Your Ref: OWPC22400
Our Ref: R/72/19/PL 02-04-2019
Please ask for:
Mrs A Gardner

Demolition of existing garage & store on existing dwelling & construction of 2 new dwellings in rear garden.

6 Manor Road Rustington

Thank you for your internet representation made on 27th April 2019 which has been recorded as '**an objection**' with the comments as follows:

DRAWING No: DS/6MANOR/03 rev 1

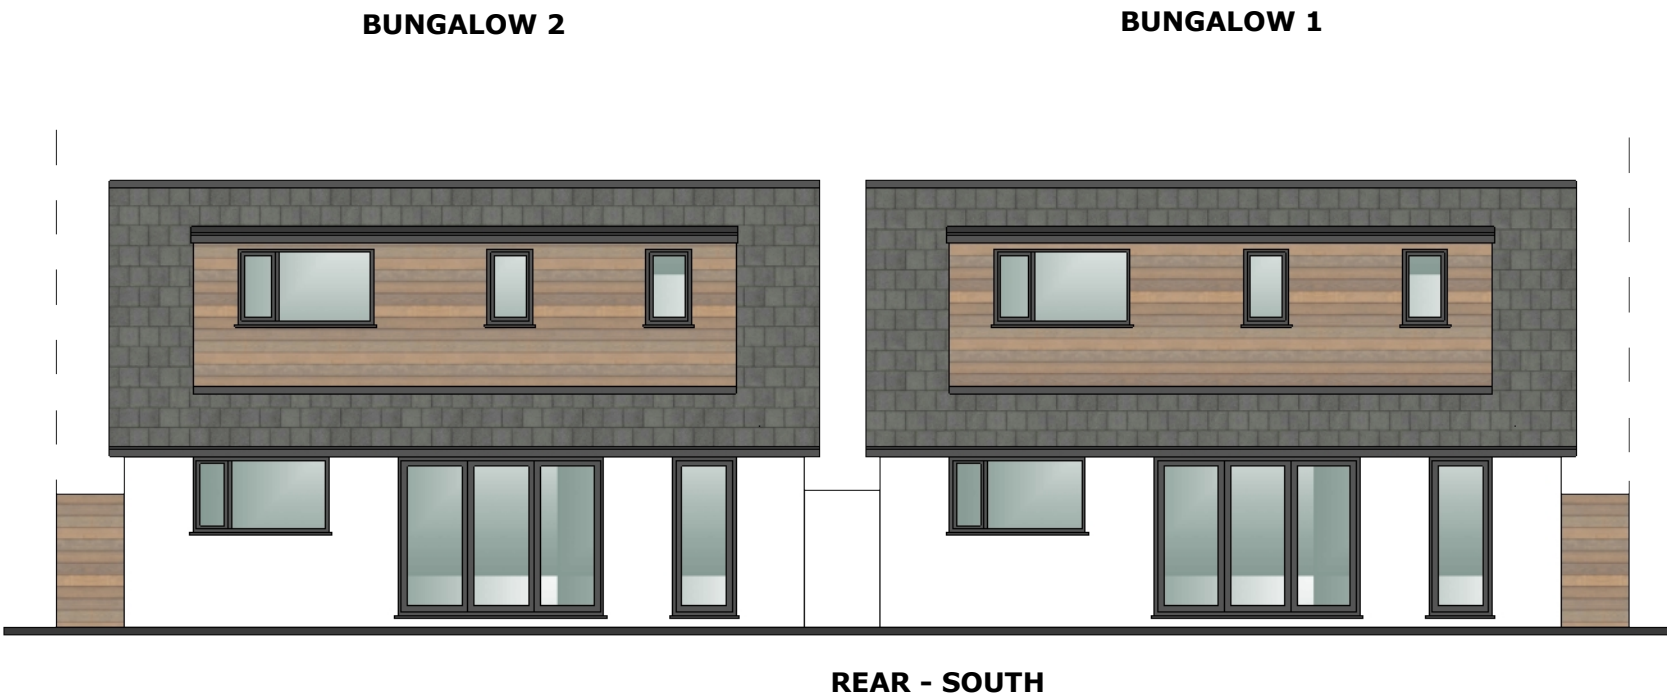
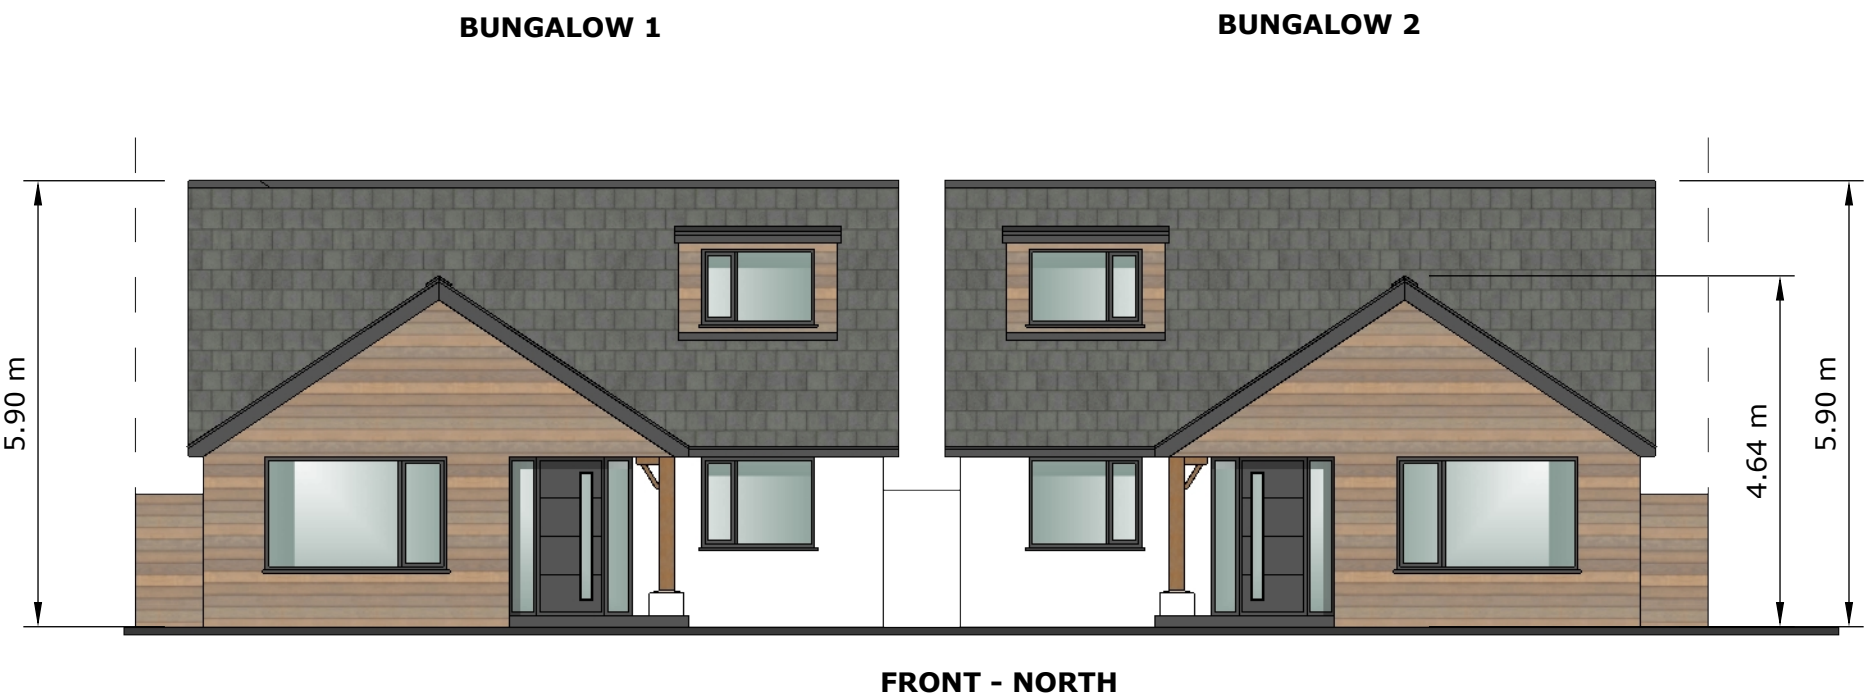
- 1. The proposed development is not sympathetically in keeping with the existing bungalows. As one of the five bungalows in Grafton Close which this development will overlook, with a ridge of 6.2m, this development will tower above us all.*

I am not against development but this looks to squeeze too much into too small a space with no thought for the existing buildings. Please consider a reduction in height and more parking spaces.
